From: Harry Chalk
Sent: 22 June 2026 08:34
To: Planning Scanning
Subject: FW: LU/101/26/PL and LU/102/26/L

From: Ben Kirk [REDACTED]
Sent: 19 June 2026 17:15
To: Harry Chalk <Harry.Chalk@arun.gov.uk>
Cc: Rebecca Tier [REDACTED]
Subject: Re: LU/101/26/PL and LU/102/26/L

Drawing Fenestration Details

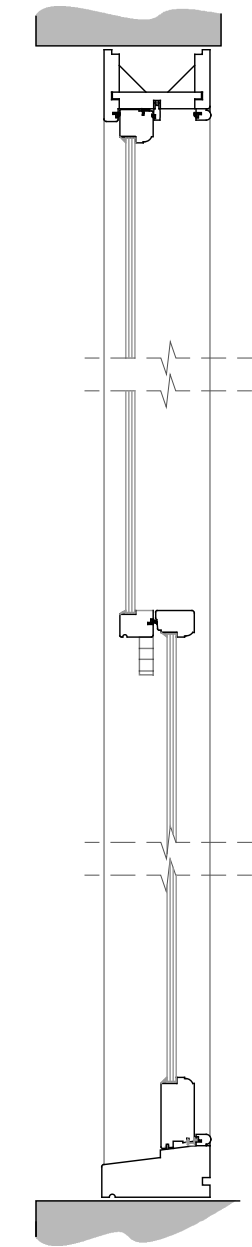
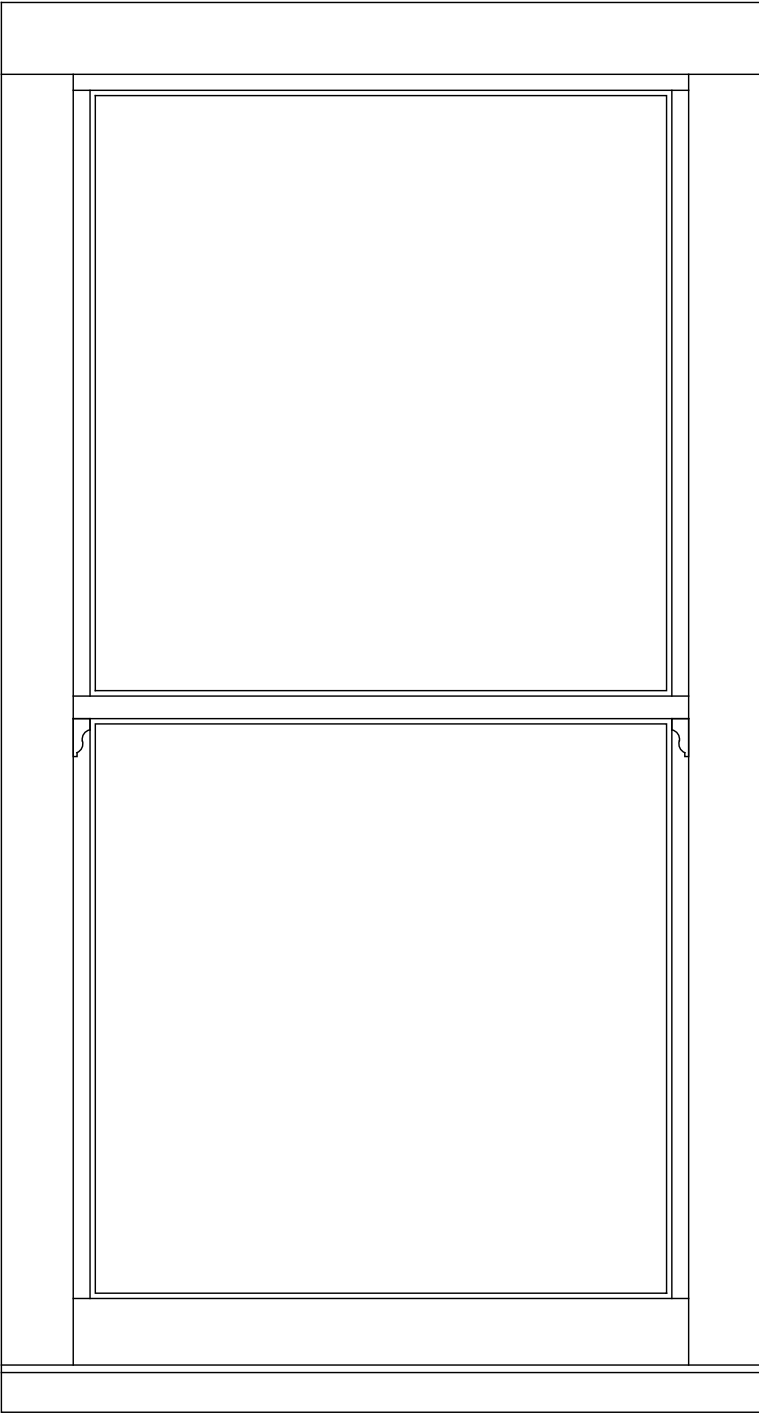
Thanks for this. The Conservation Officer had requested a condition securing final details of the proposed windows. However, most of the detail sought by the condition has been provided, and in further discussion, all that remains really is the finish/colour of the replacement windows.

I understand they are to be painted, and I assume a white/off-white colour. If this has not yet been confirmed, we can leave it to condition, but to avoid the need for this, do you have confirmation of the finish of the windows? If so, would you like to clearly state what paint/colour is to be used? T

All windows will be painted white / off white
